Development Facilitation Team (DFT) – Review Comments

DRB Project No: PR-2020-003484 Date: 06/28/2023 Agenda Item: #9 Zone Atlas Page: E-10

Legal Description: Lots 2 & 3 Block 12 unit 3, Volcano Cliffs SUBD

Application For: SD-2023-00048 – PRELIMINARY PLAT (DHO)

**MOJAVE SUBDIVISION**  
 GRADING AND DRAINAGE  
 GRADING PLAN

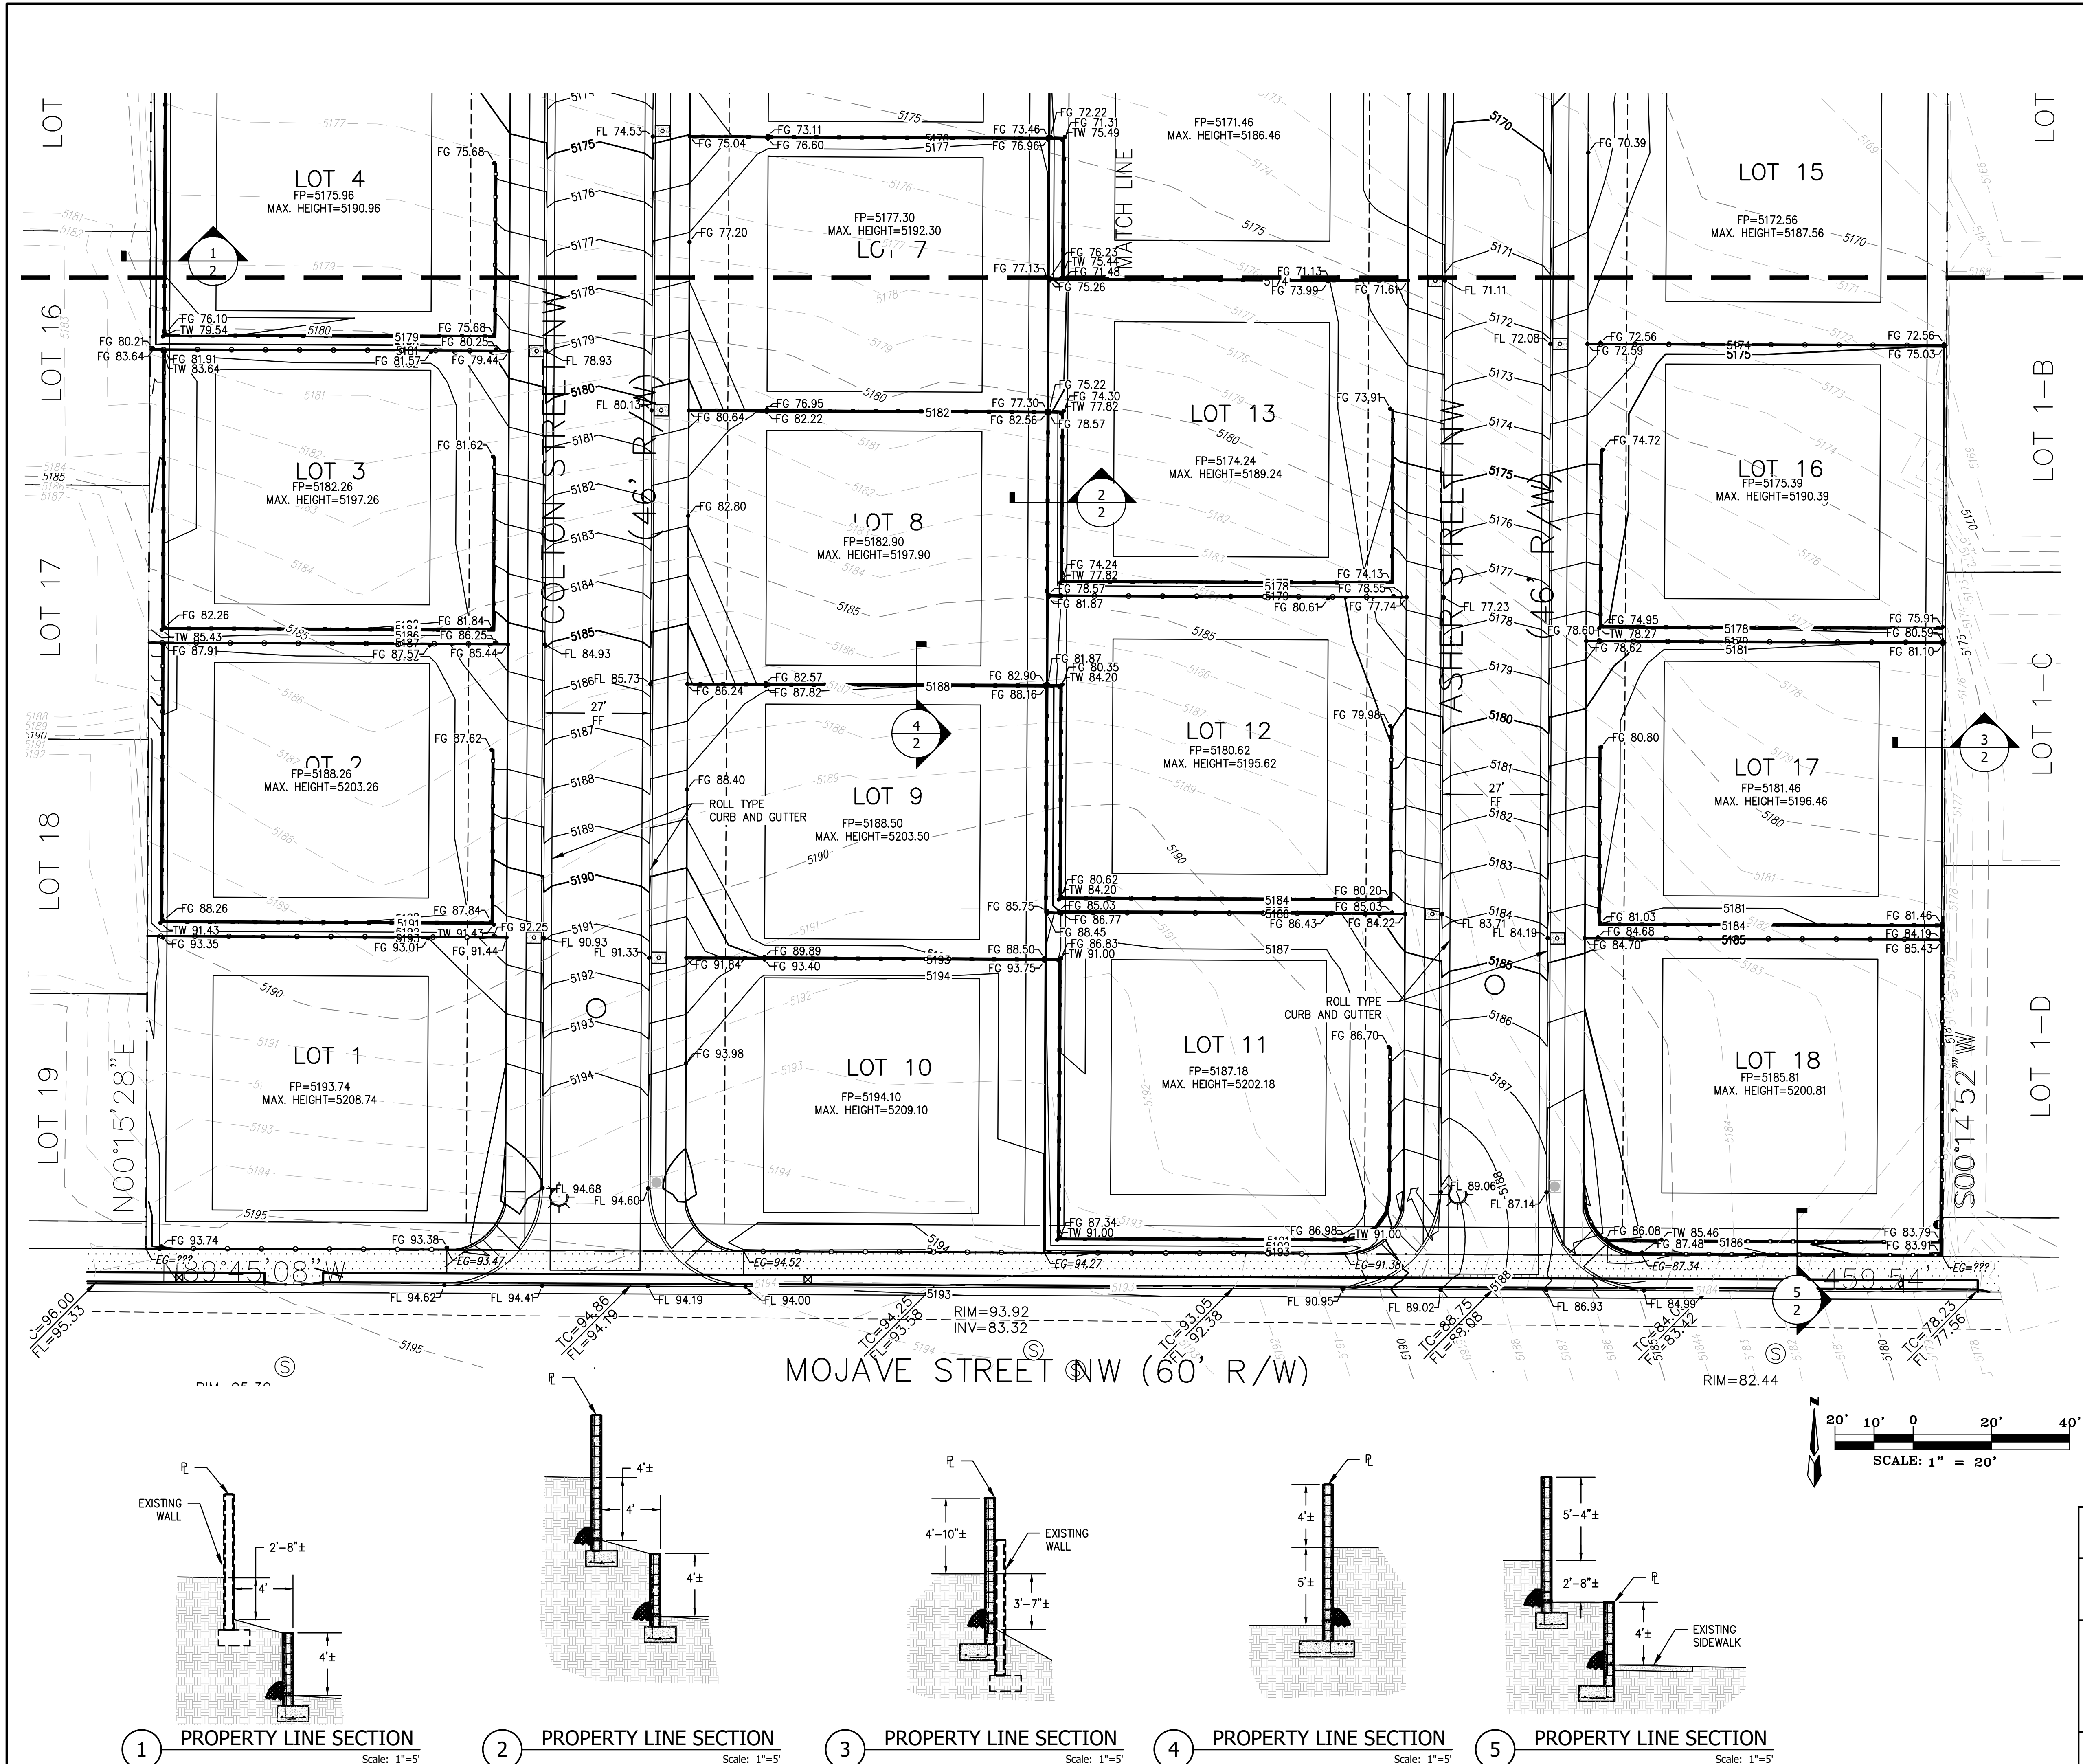
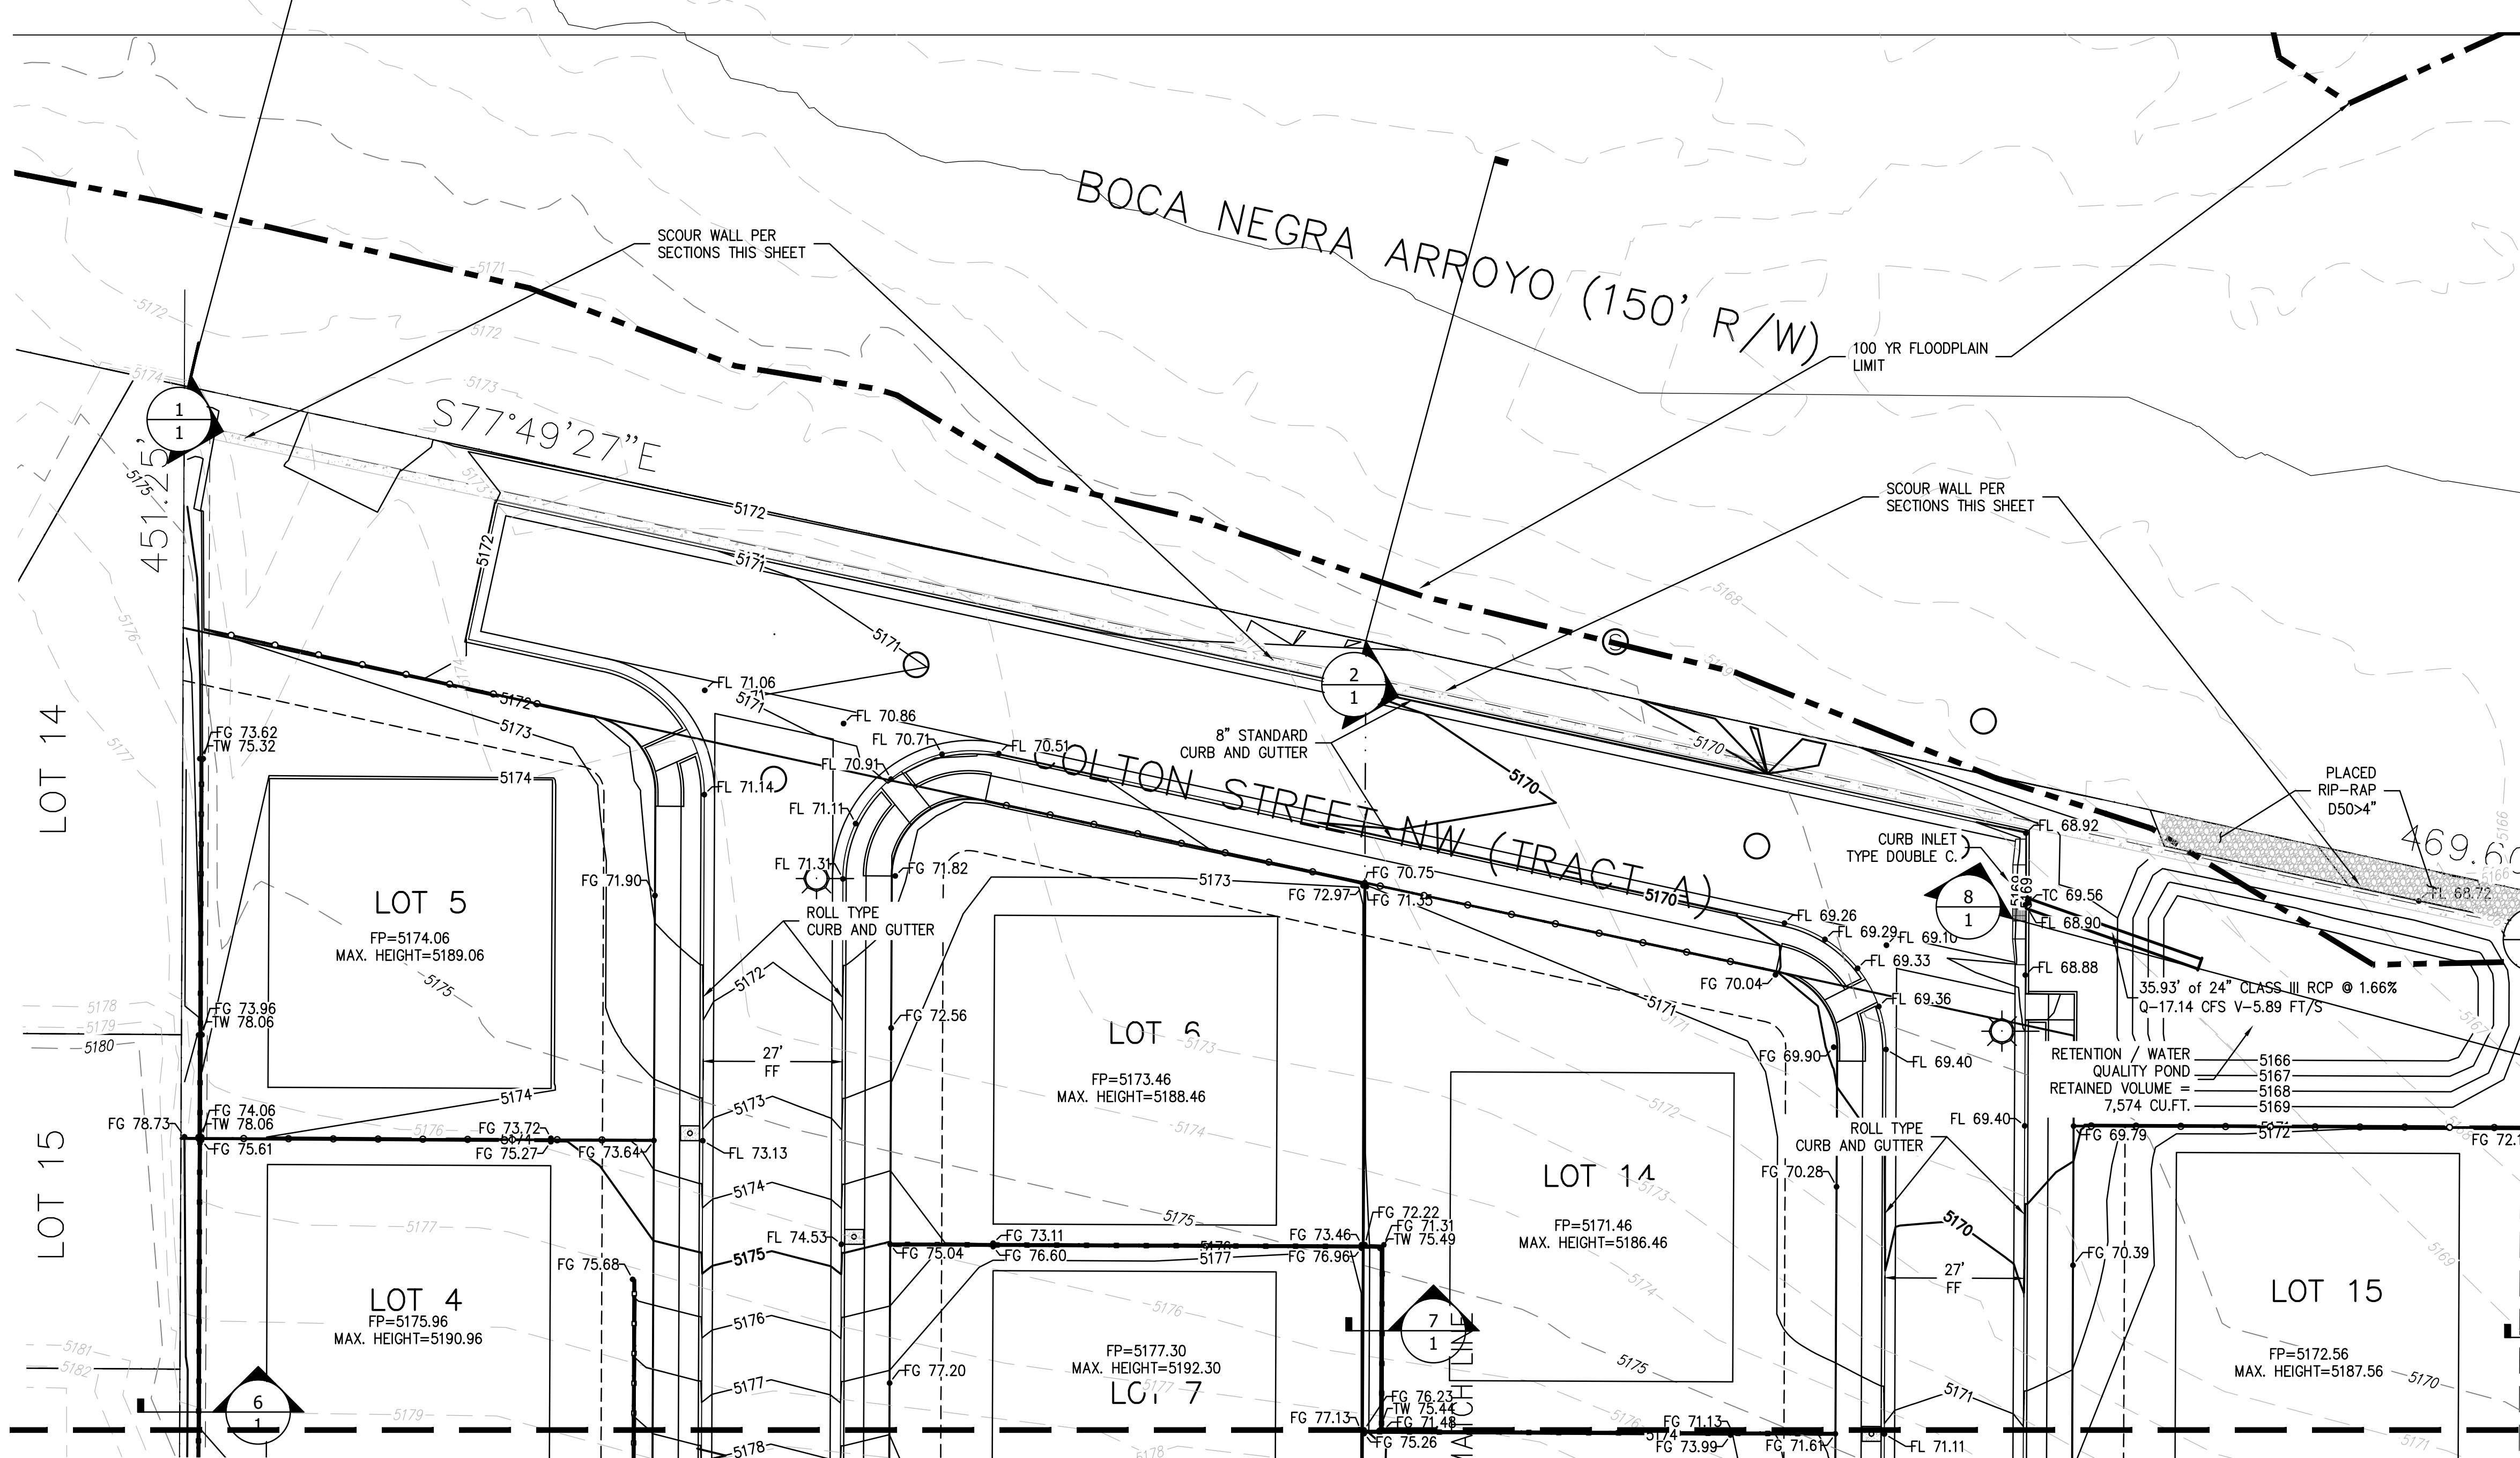
- Hydrology has an approved Revised Grading & Drainage Plans (E10D024) with engineer’s stamp date of 05/15/23.
- Hydrology needs approvals from National Parks and Open Space.
